Permit No: **980700**

BUILDING PERMIT REPORT

DATE: 6/30/98 ADDRESS: 205-210 High St Rear
REASON FOR PERMIT: rebuild deck
BUILDING OWNER: D+G Mfg. Co
CONTRACTOR: Bruce Meyers
PERMIT APPLICANT: _____
USE GROUP R-2 BOCA 1996 CONSTRUCTION TYPE 5B

Specifications

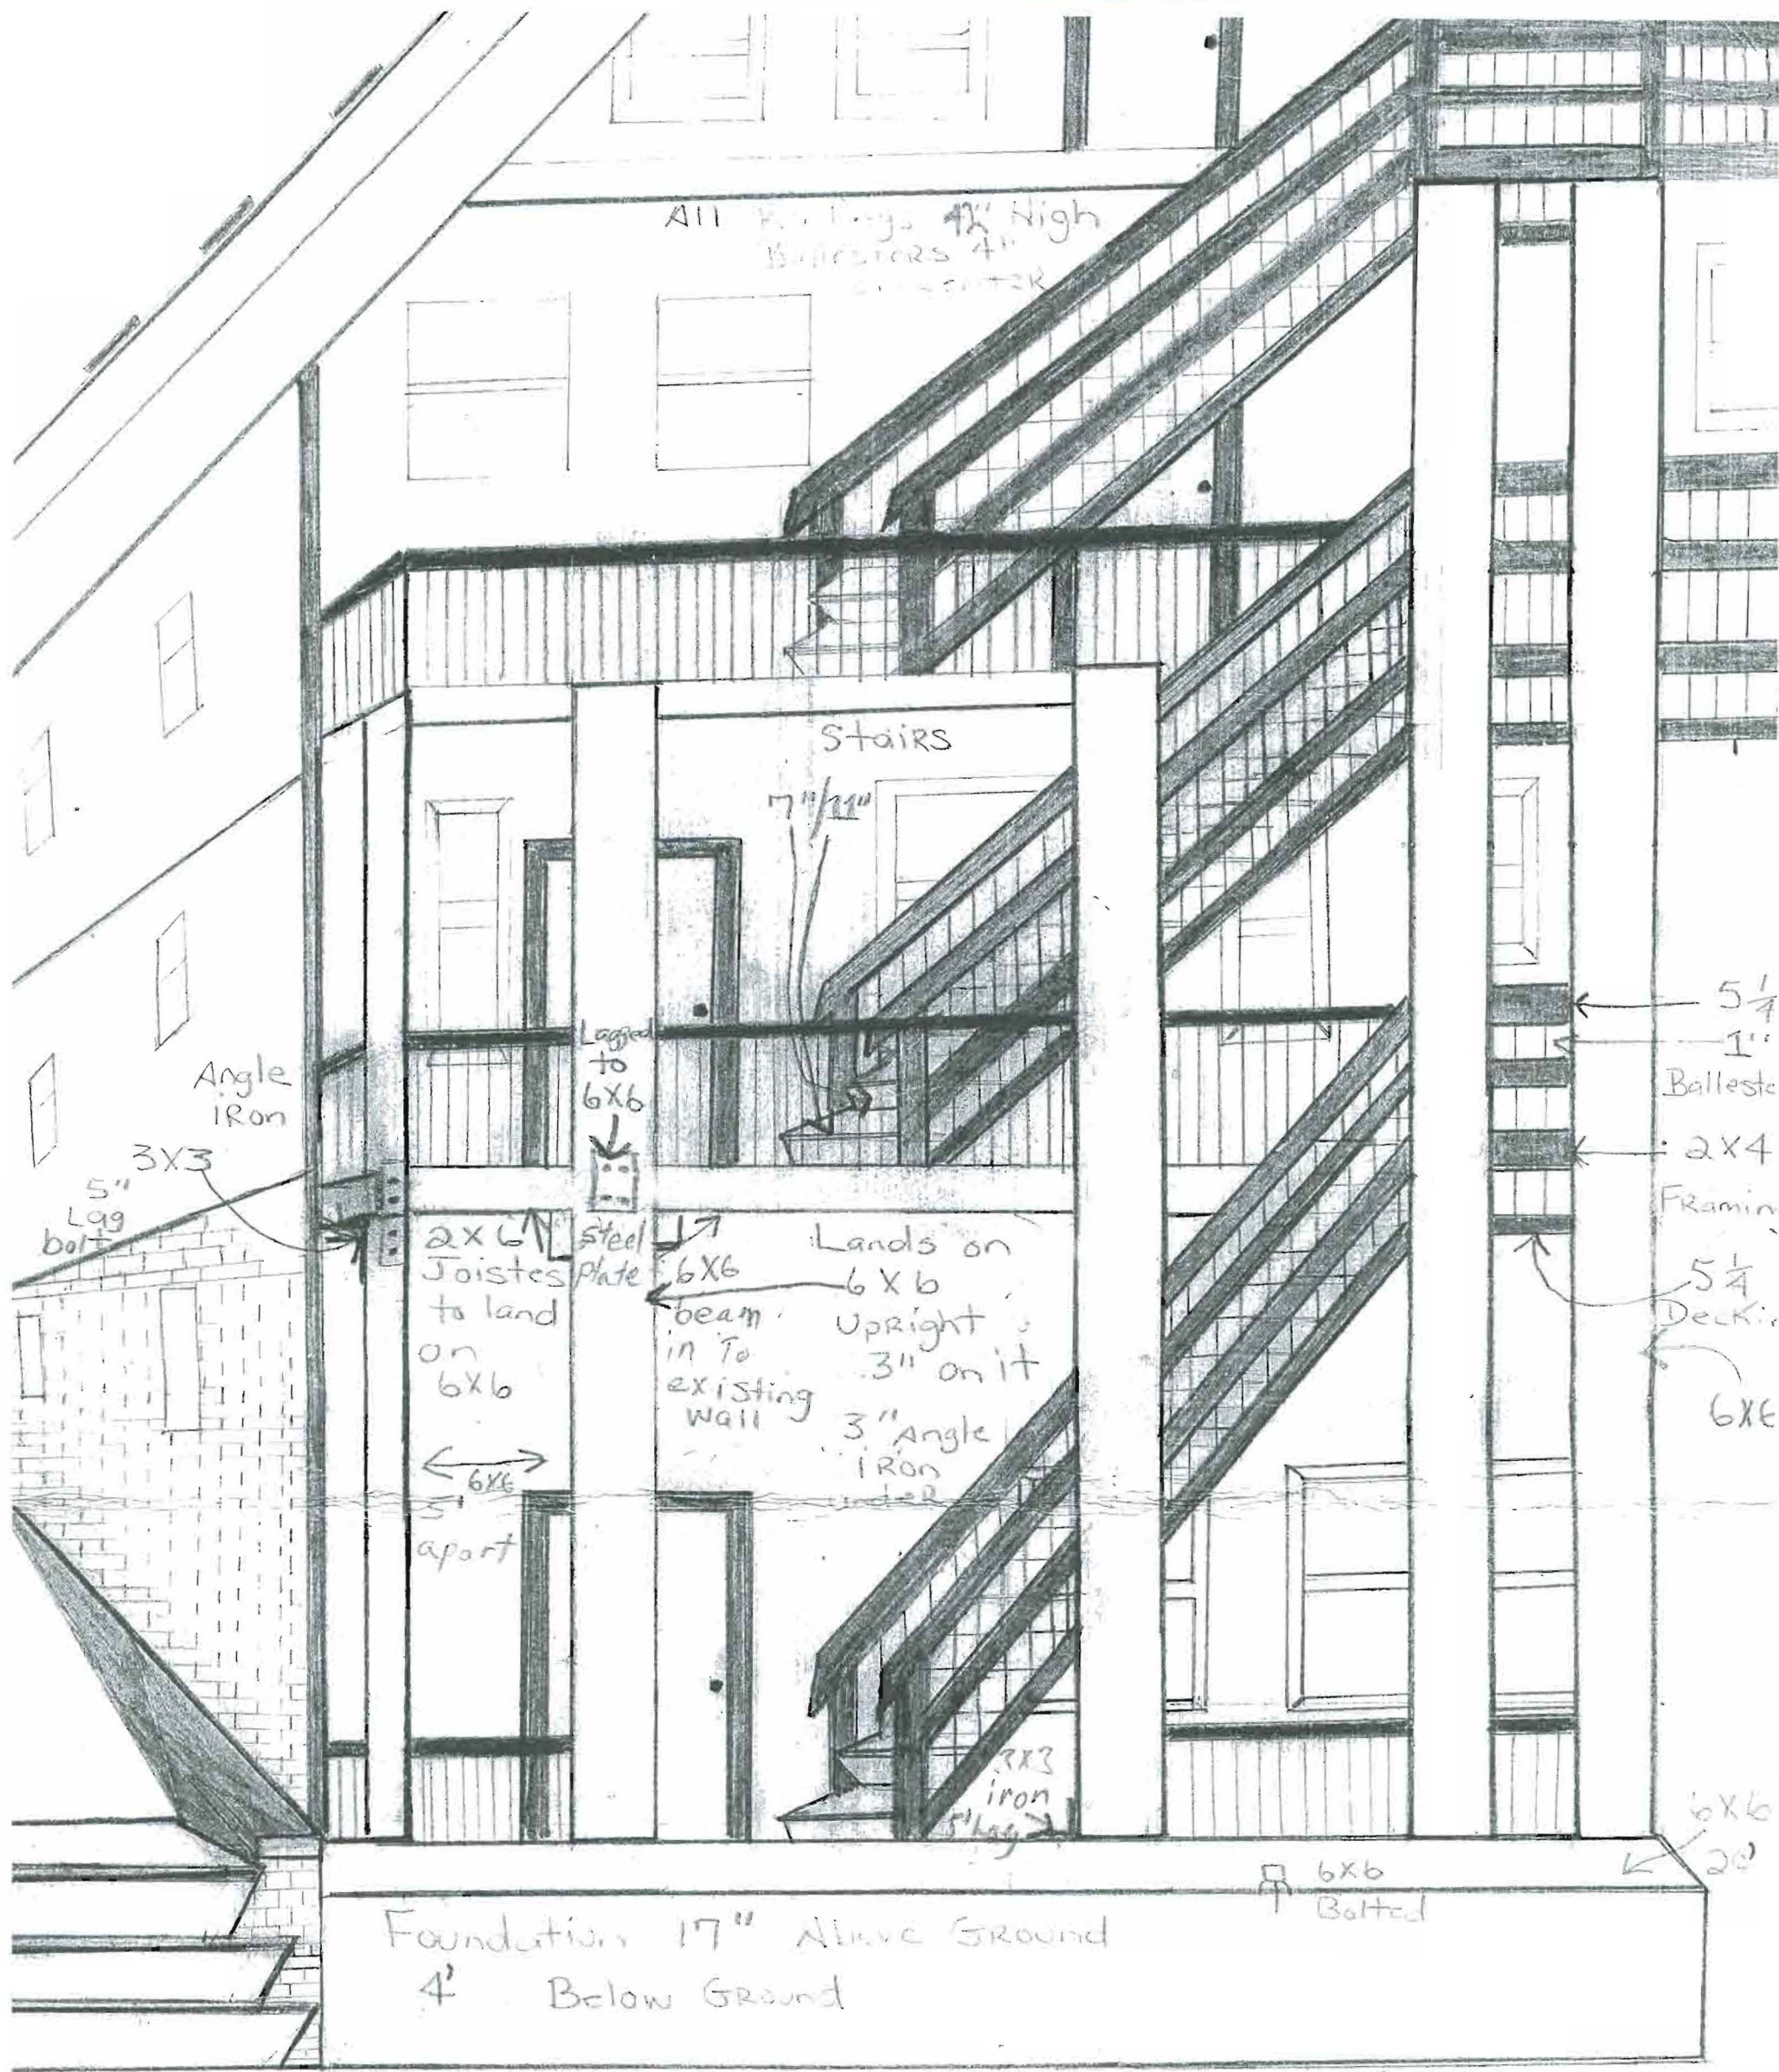
Sam & Mac will Decide on 9/2/98 we visited the site and the decision was made that Bob Marine will submit a letter and plan stating what is presently their and acknowledgement that when the stairs are replaced they will have to meet the 7" Rise and 11" Tread Rule (TER)

29. *Second means of egress shall be maintained during construction.*
30. *Handrails shall be graspable 1 1/2"-2" in diameter.*
- X 31. *Proposed deck NOT To exceed existing footprint.*
